plat review1 responses.pdf Markup Summary

## AS REPLATTED

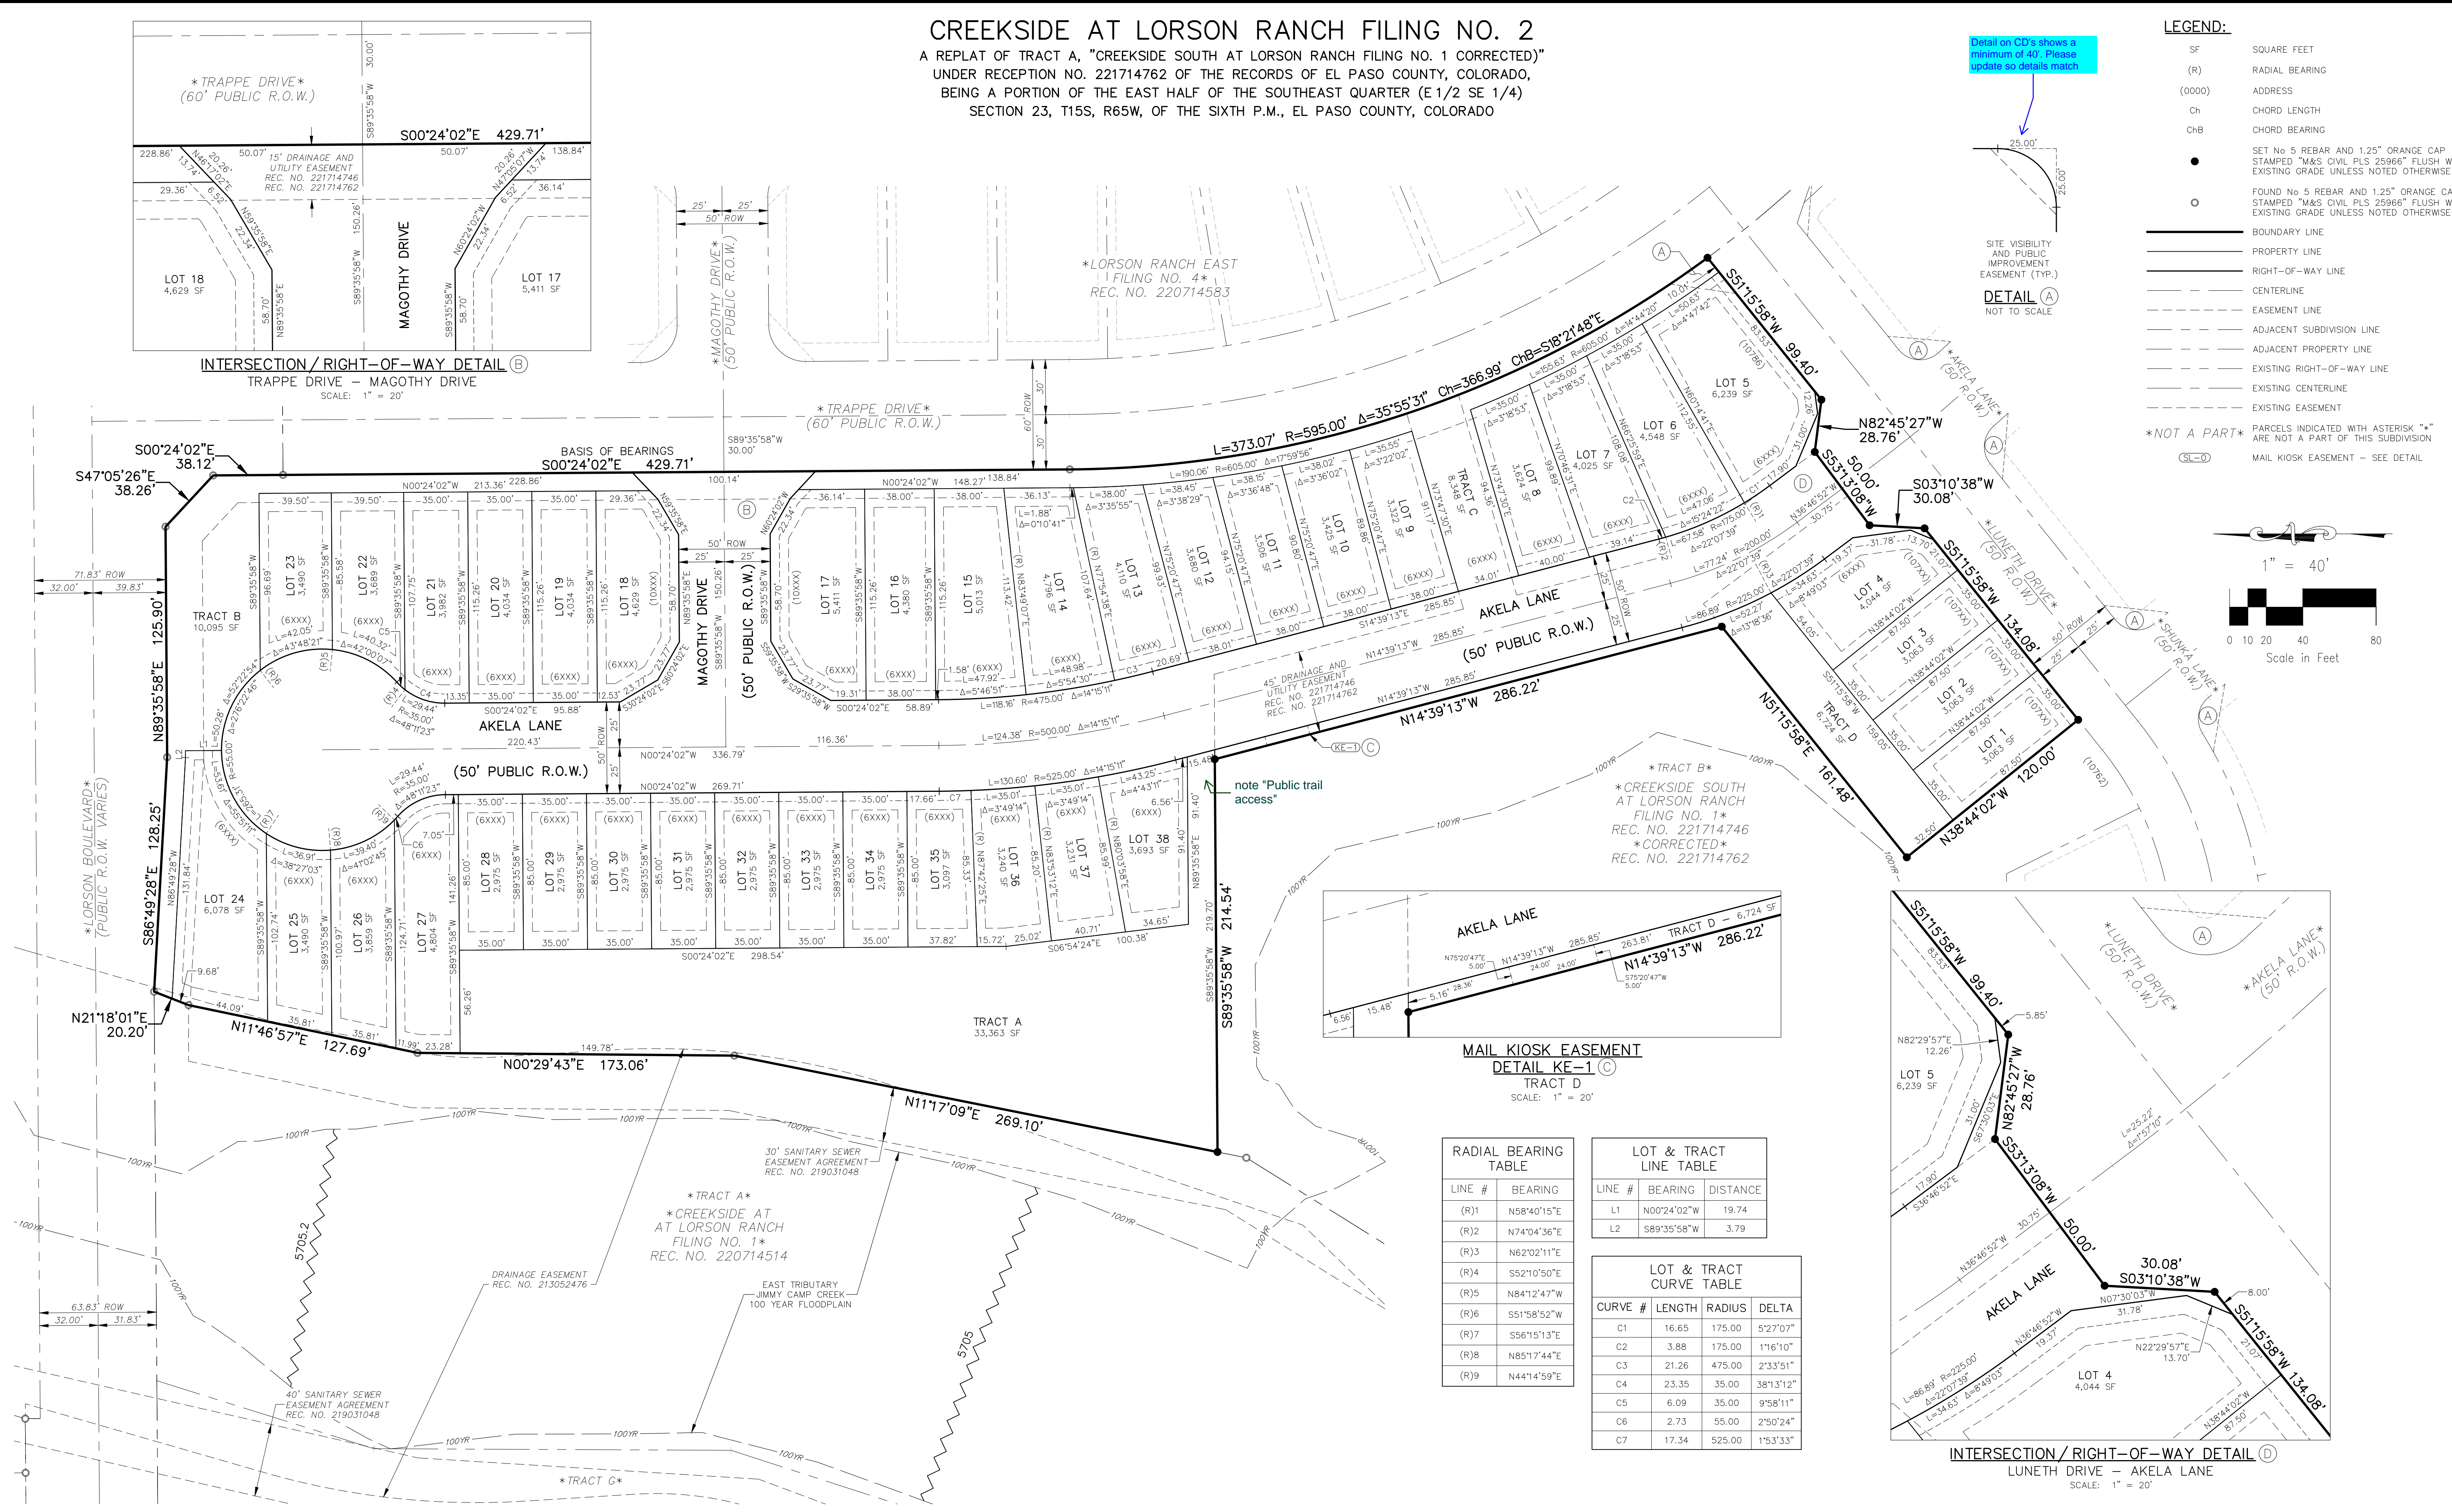
Detail on CD's shows a minimum of 40'. Please update so details match

All easements shown on this plat referencing Detail A were previously recorded with on the plat of Creekside South at Lorson Ranch Filing No. 1; as such, they cannot be revised by this plat. With regards to the new intersection corners, the combination of right-of-way design and public improvement easement requirements provide adequate coverage so that lot corner easements are not needed.
